**Re: Subject: PA22-015 Colvin PRD  
3920 Densmore Road  
APN's: 00590700023505 & 00590700024400  
Core Project No. 21387**

The purpose of this letter is to provide a response to the review comments for PA22-015 Colvin PRD dated May 9, 2022. We have addressed each comment and revised the plan/documentation accordingly. This letter contains the review comments immediately followed by our response to each in bold lettering.

MAINVUE WA, LLC
 1110 112TH AVE NE, STE 202
 BELLEVUE, WA 98004

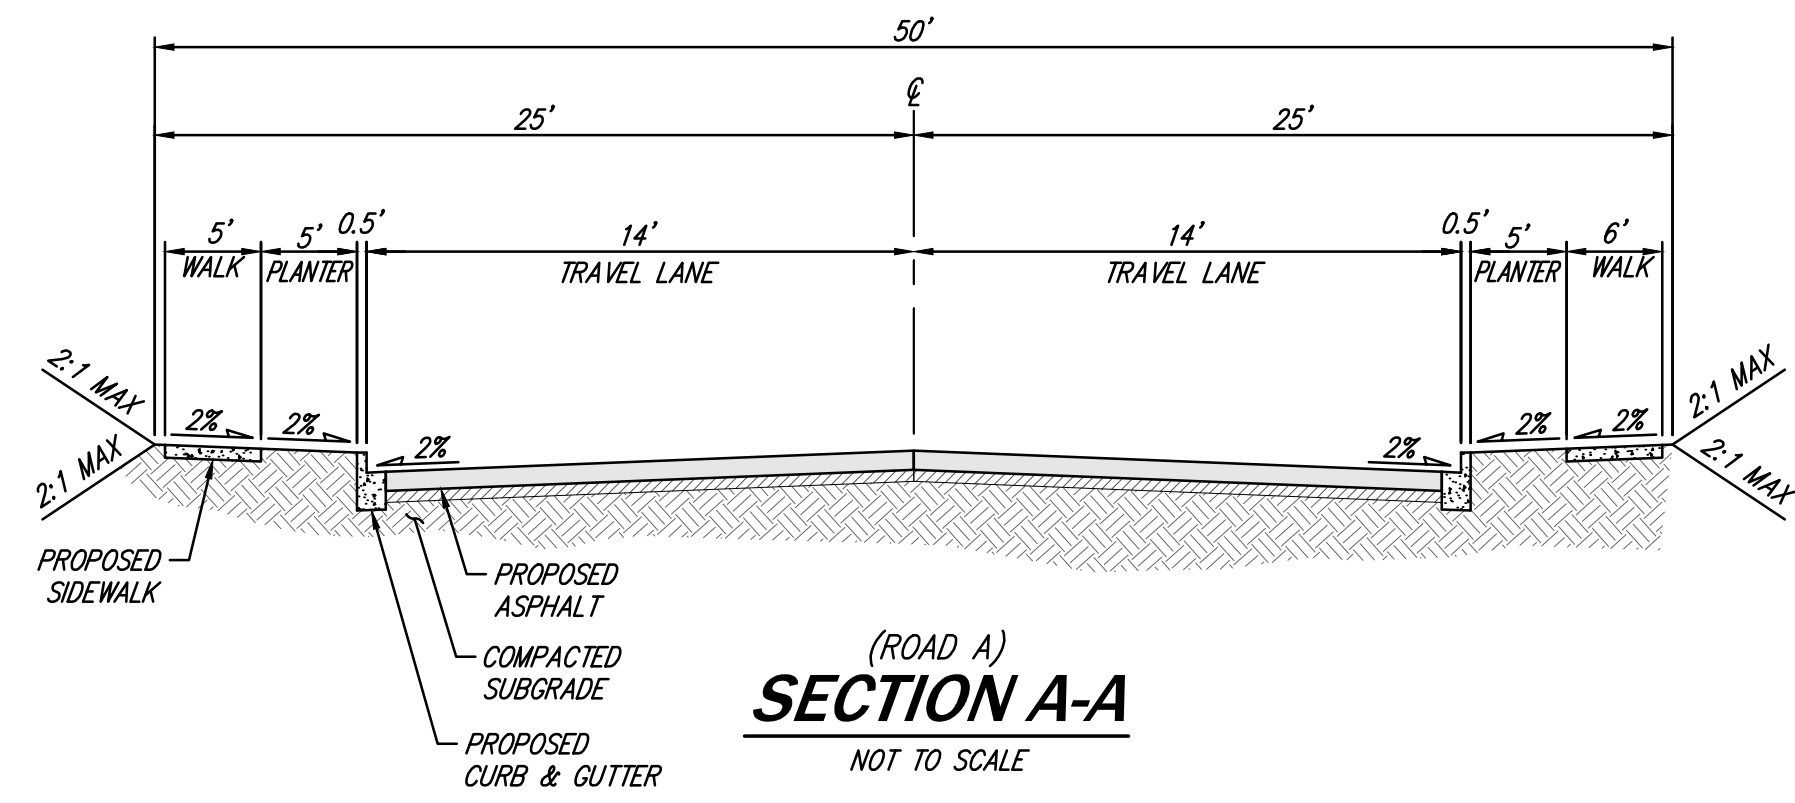
3. Based on review of Sheet C4.01, there appears to be multiple retaining walls exceeding the allowable 4 ft. threshold, which requires wall terracing. Please clarify how compliance with MMC 22D.050.030(4) is to be satisfied for the proposed retaining walls exceeding 4 ft. in height

***Response: Walls have been proposed with a max height of eight-feet. Walls exceeding four-feet in height have been designed so they are not be visible from neighboring properties. The eastern walls are proposed to be cut walls and are anticipated not to be visible from the eastern neighbors since they are at a higher elevation. The western walls are proposed to be fill walls and area also anticipated not be visible to the eastern neighbors. The only visual impact anticipated as a result of the walls would be to vehicle traffic and pedestrian traffic along Desnmore Road. Wall details and design will be provided by a geotechnical or structural engineer during Civil Review. If necessary, the applicant will apply for a deviation.***

LANDSCAPE PLAN

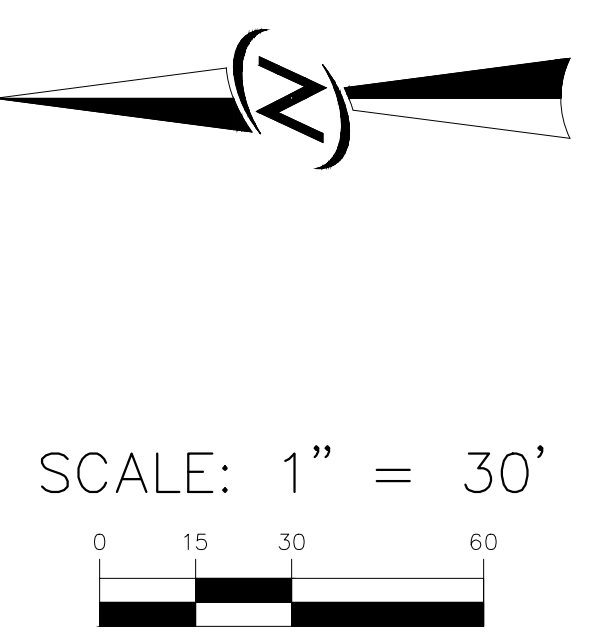
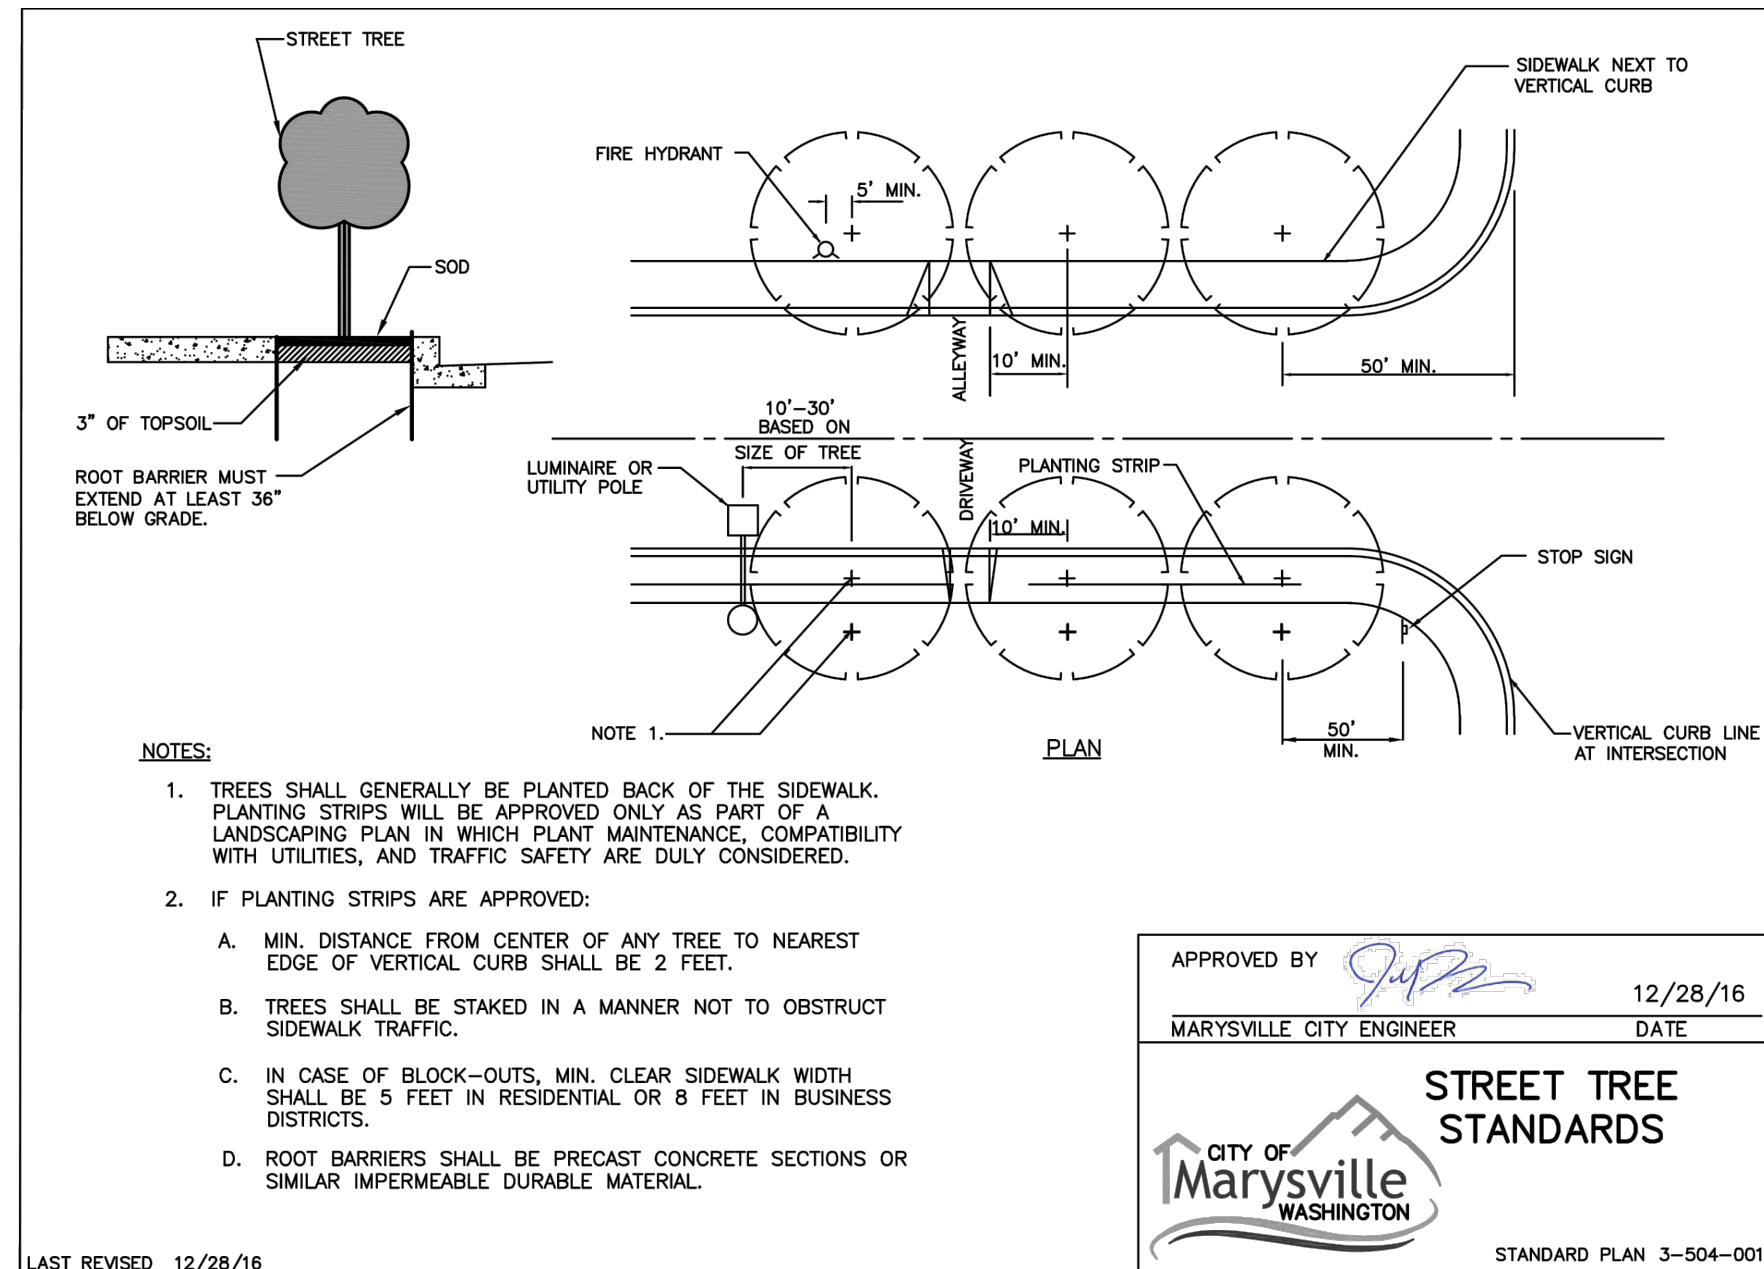
4. Based on the application materials, RDI 7b per MMC 22C.090.030 is proposed. The landscaping plan on Sheet L2.01 is not clear as to how “retention or creation of a perimeter buffer” is proposed as a 6 ft. perimeter fence is shown.

Please provide a detailed depiction of the proposed 5 ft. compatibility perimeter buffer, including all vegetation to be retained.

***Response: Perimeter buffer for the purposes of achieving RDI is no longer proposed.***
